Our Ref: BE/136/10/

Outline application with some matters reserved for the erection of a terrace of 4No. 2 bedroom houses. (Resubmission following BE/105/10).

Land Adjacent to 346 Chichester Road Bognor Regis

SITE PLAN

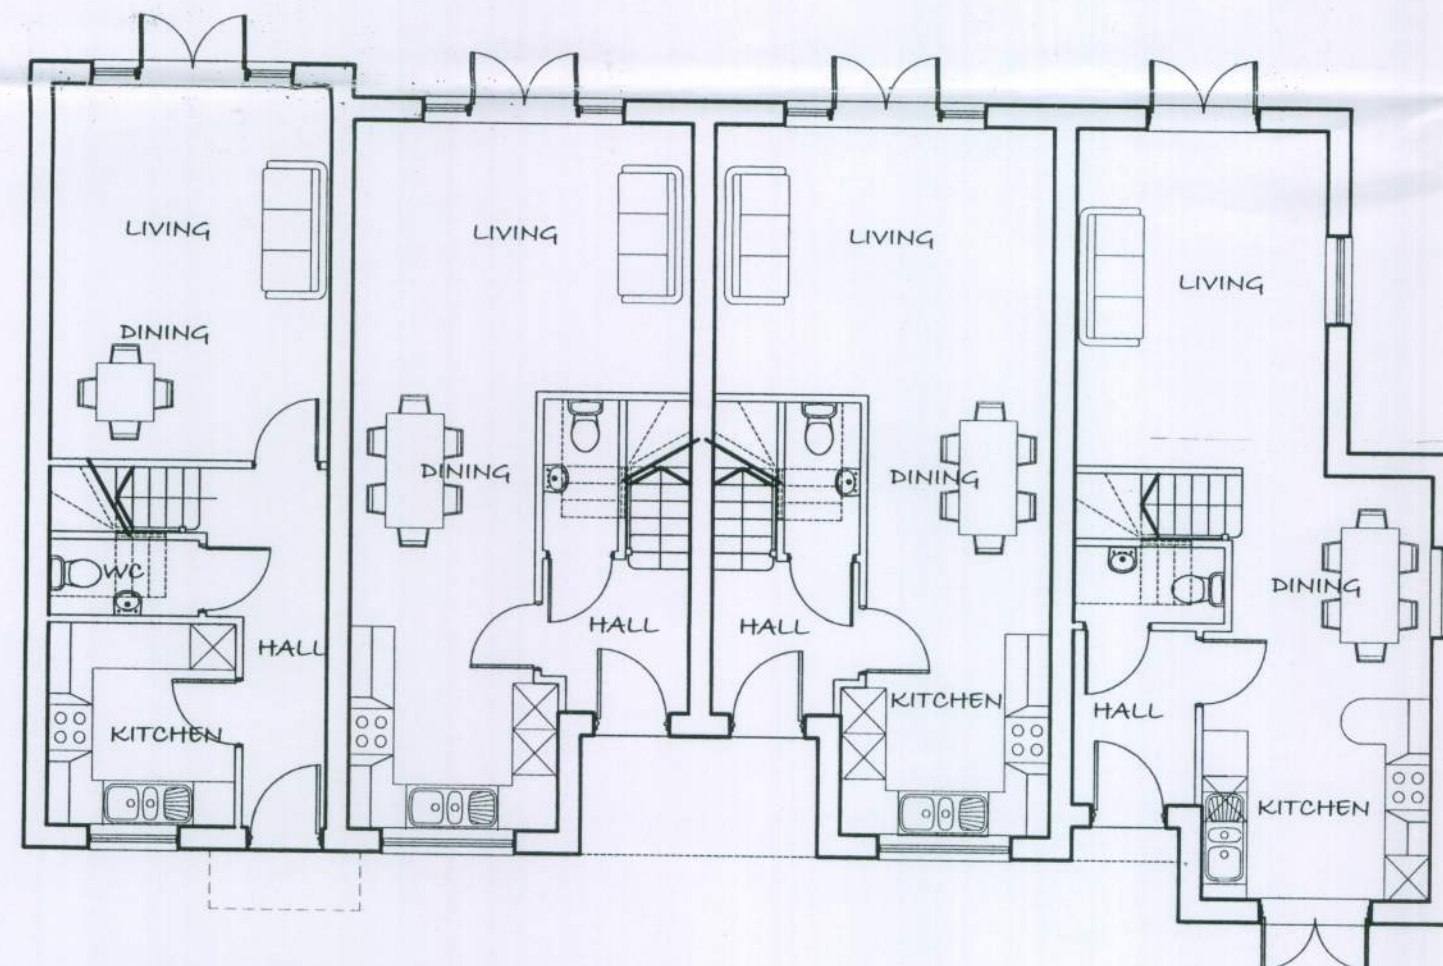
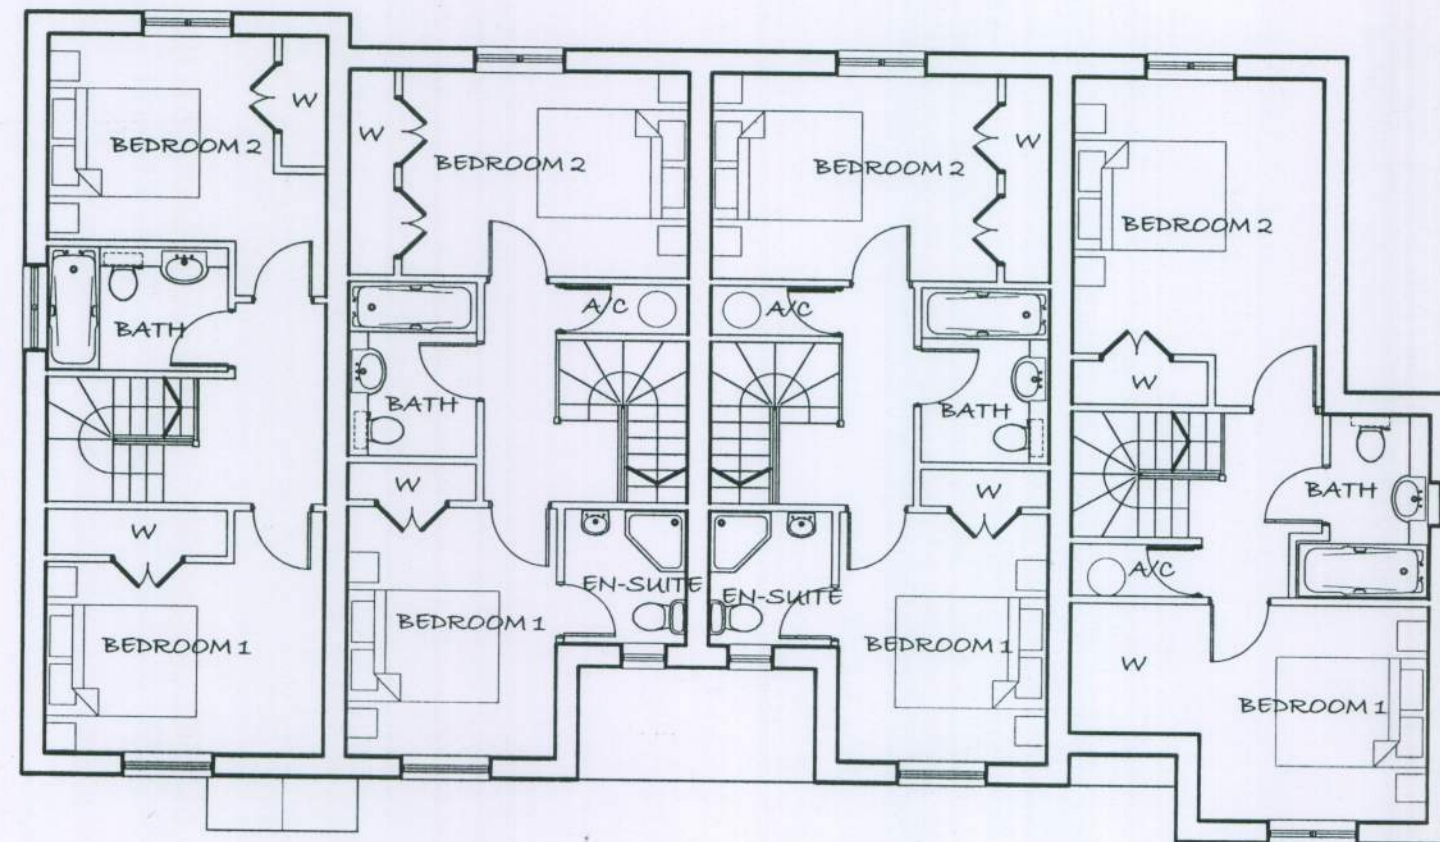
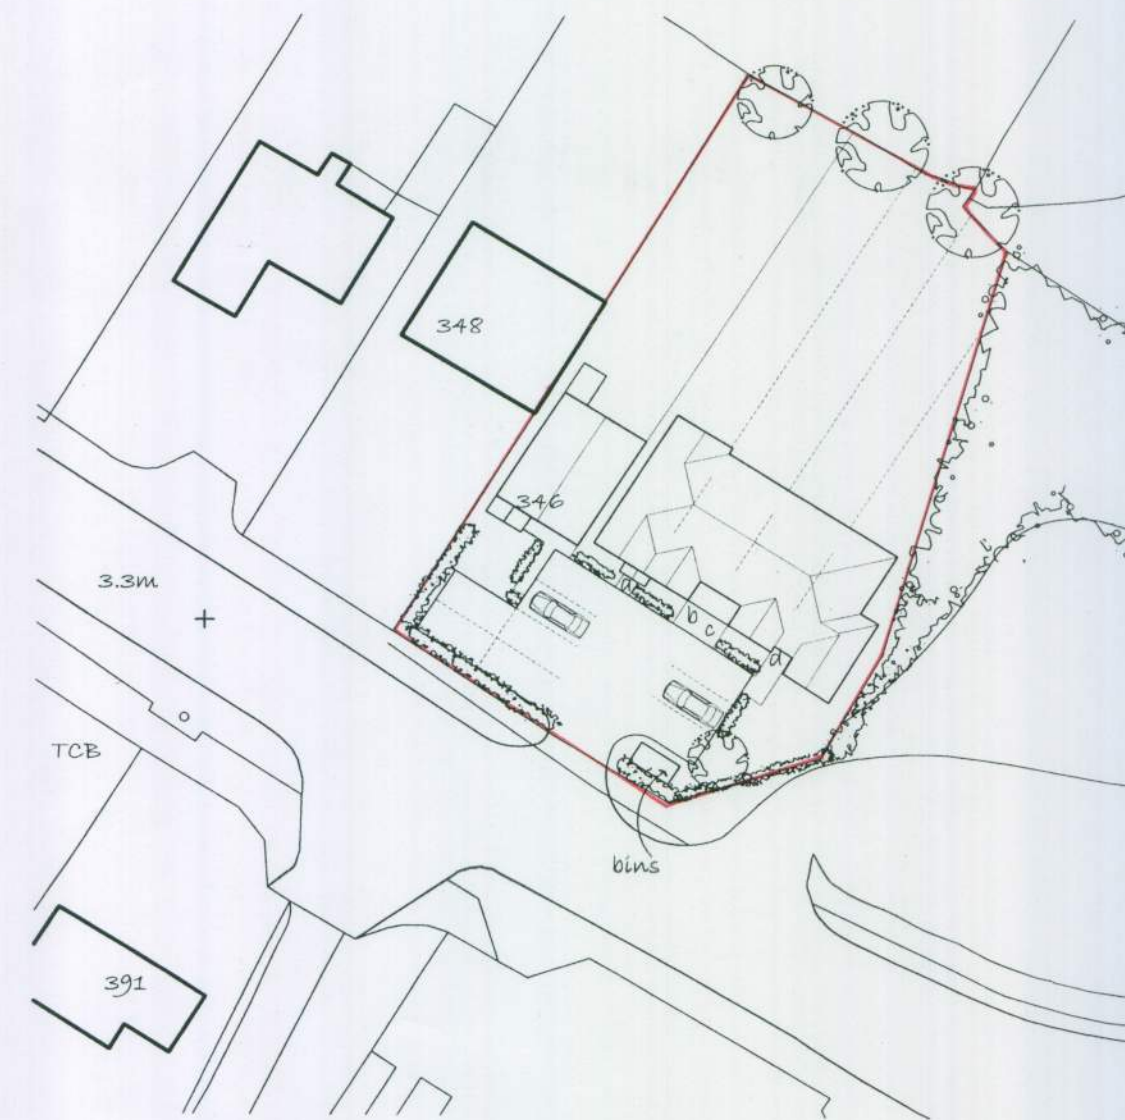
Object for the following reasons, 1) It is an overdevelopment of the site, 2) The proximity to the A259 roundabout and the Royal Oak is considered too close, 3) Vehicular access to and from the A259 is too restricted and 4) Drainage, soak aways & surface water disposal needs investigating & the effect of the increased waste on the existing system & how it would be connected to the existing system needs further clarification.
